From: Lawrence Stringer [REDACTED]
Sent: 22 December 2016 12:45
To: Jamie Brown
Cc: T Croucher; Claire Potts
Subject: RE: AL/111/16-OUT Land East of Orchard Gardens Woodgate

Following your initial highway comments on the improvements proposed for the above development, I have now updated the drawings.

WSCC Highways – see attached - Objection ‘Given the points raised above the LHA does not at this stage have sufficient information to provide a recommendation for this application. The applicant will need to revise the proposals paying attention to the points raised above relating to the previously agreed highway improvement works.’

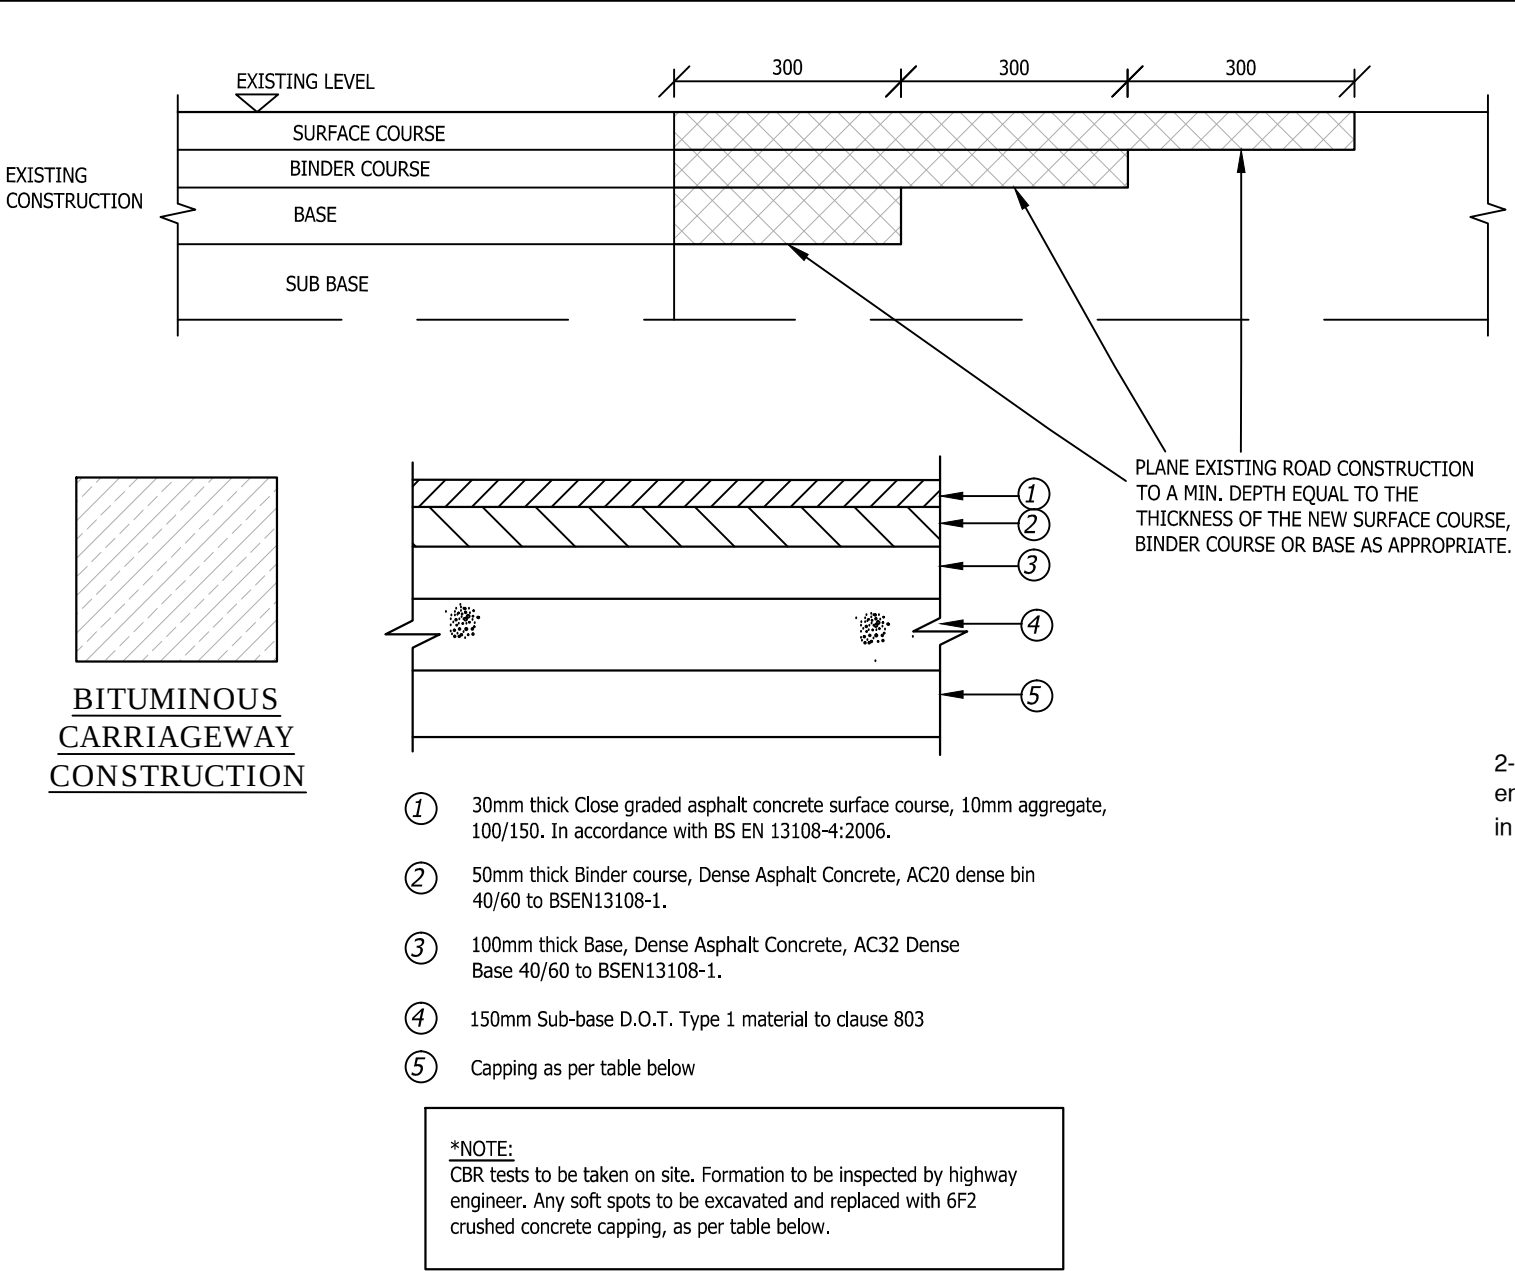
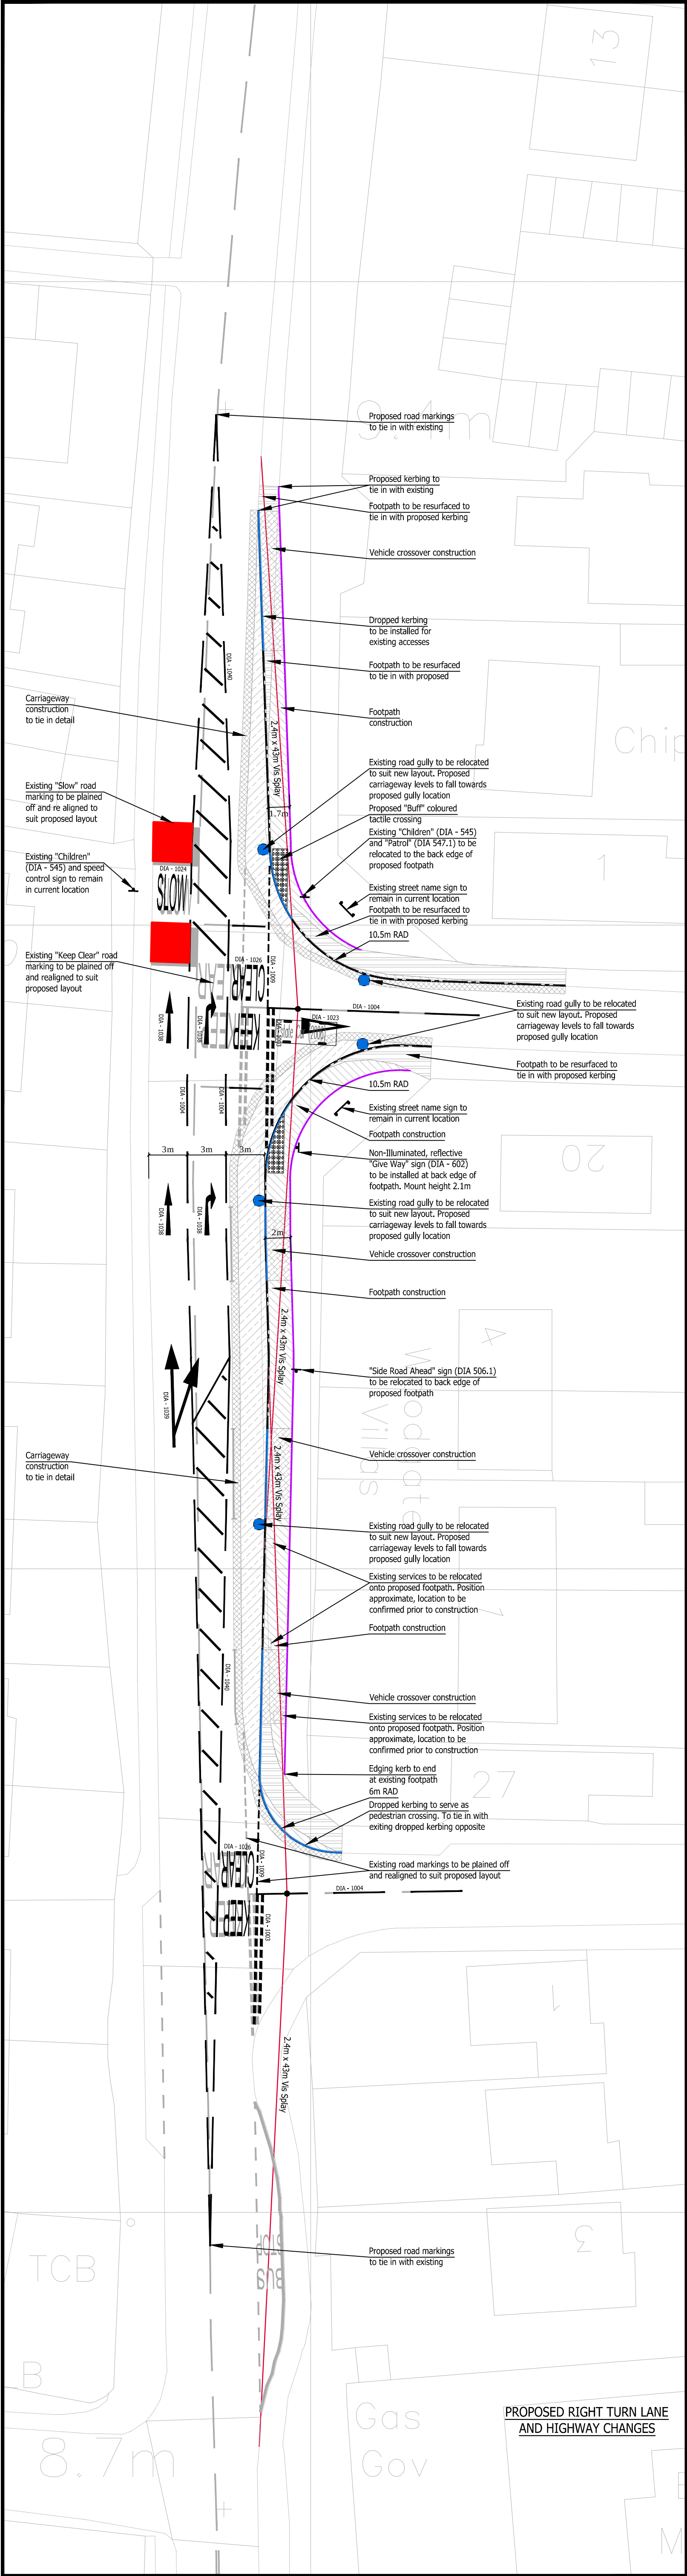
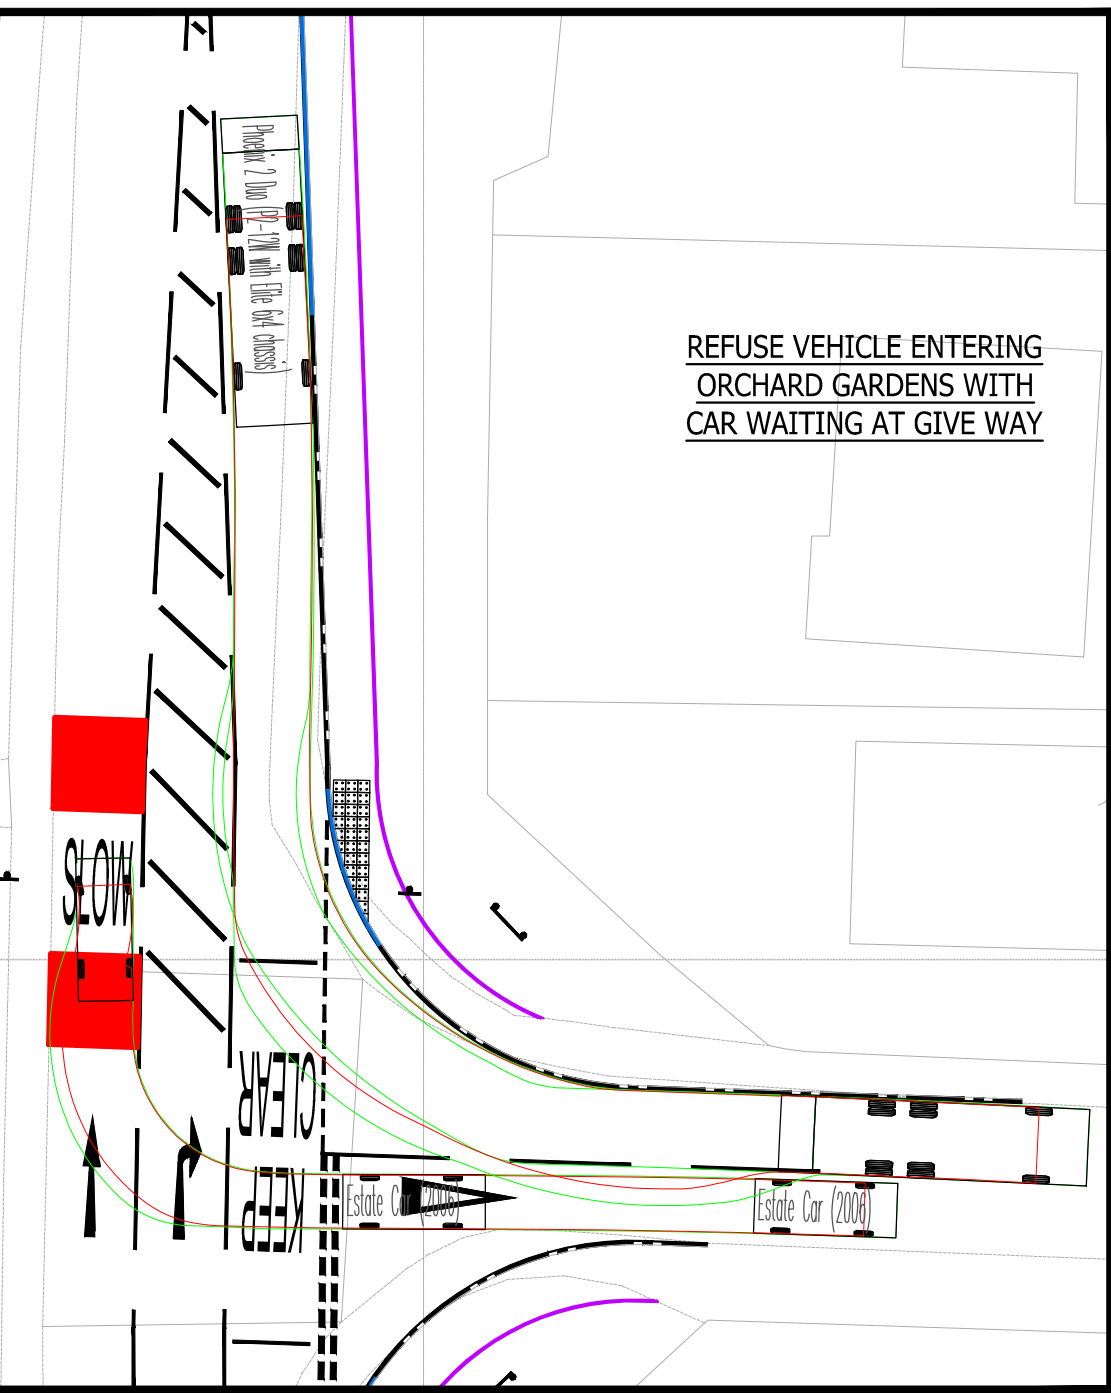
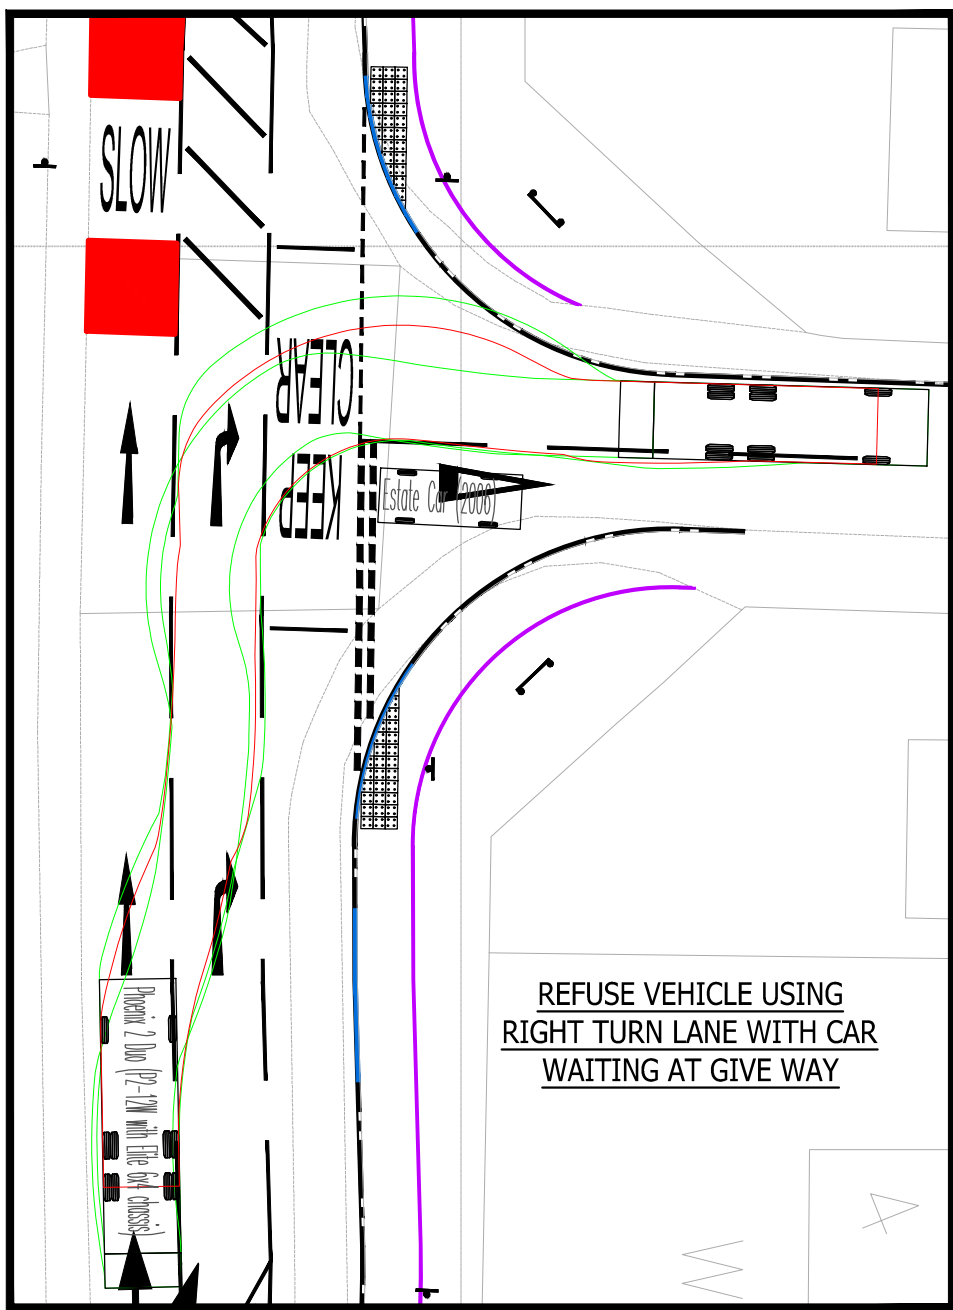
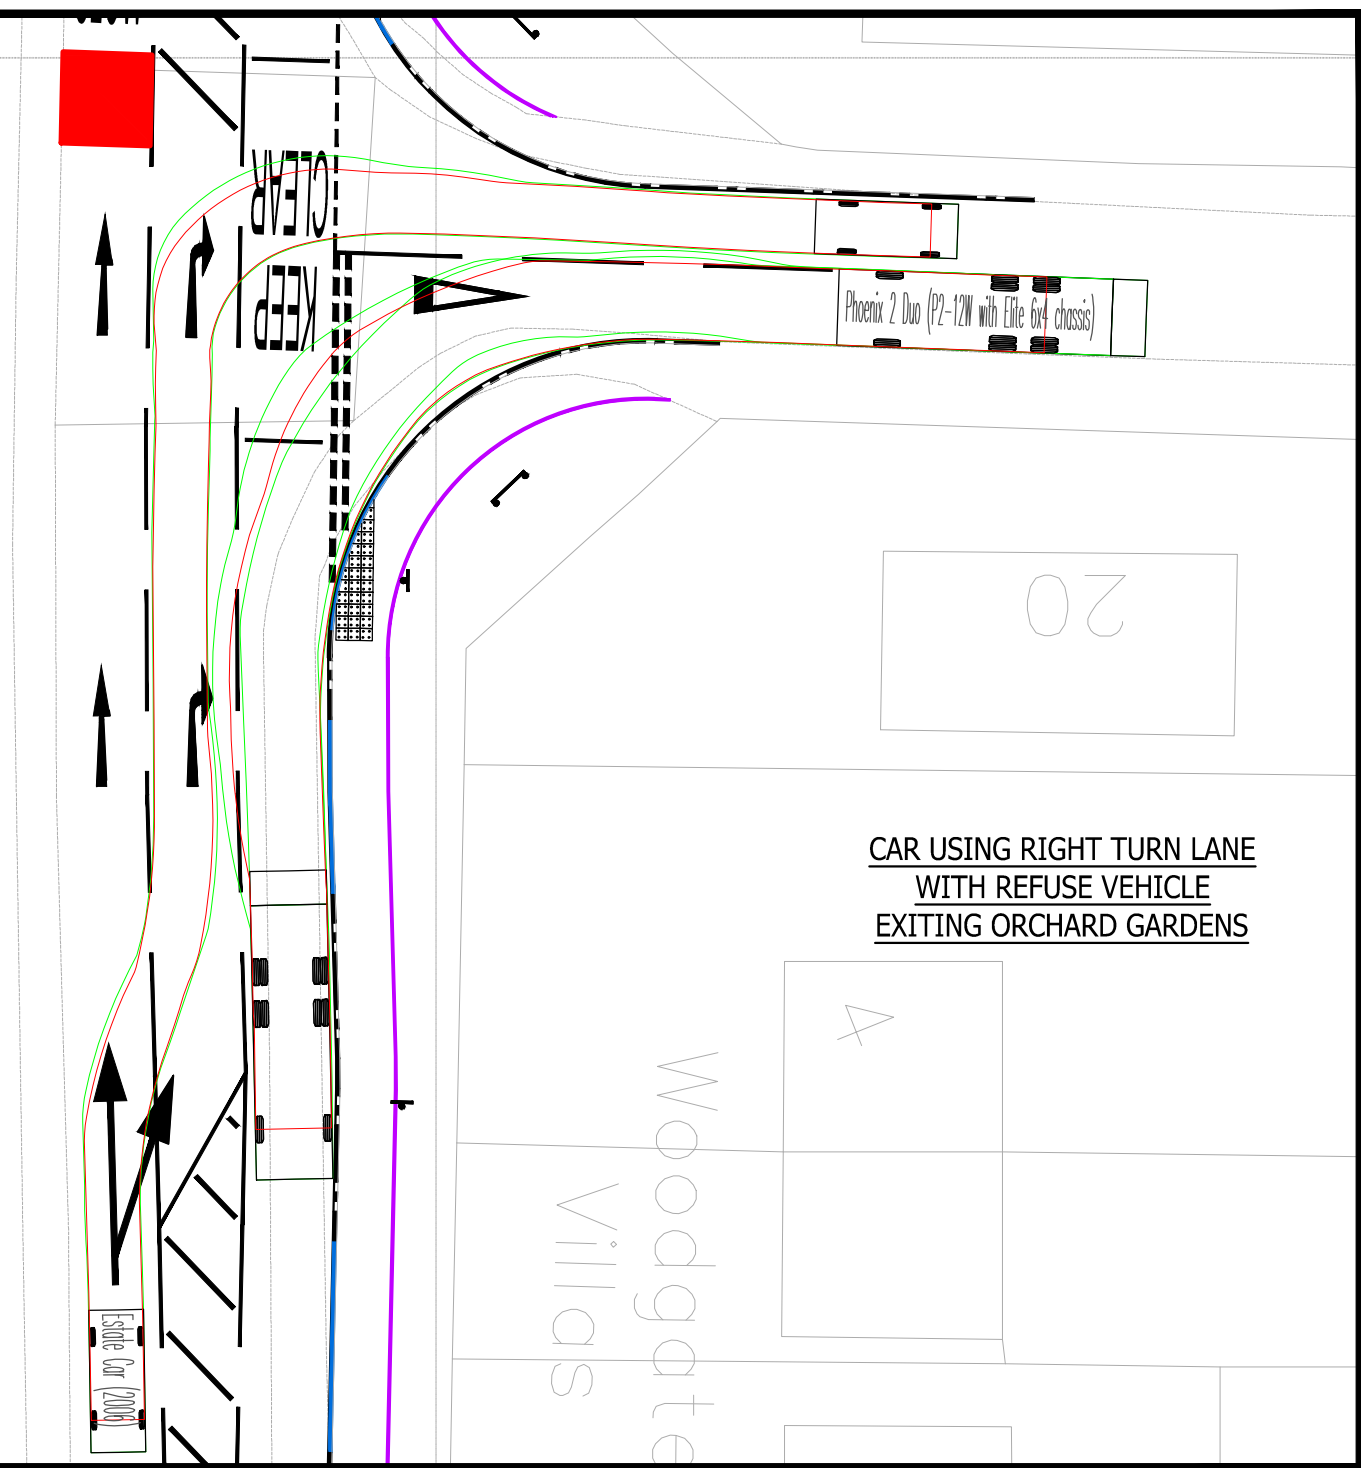
1. Demonstrating that the proposed RTL at Orchard Gardens can easily connect to the RTL proposed as part of the Hook Lane approved application;
2. Accommodating the relocated bus stop and shelter;
3. Demonstrating refuse vehicle turning within the site

The above shows that the two RTL's will simply join with central hatching rather than a taper as is the case in urban situations. This change is not considered to warrant the need for a new RSA1.
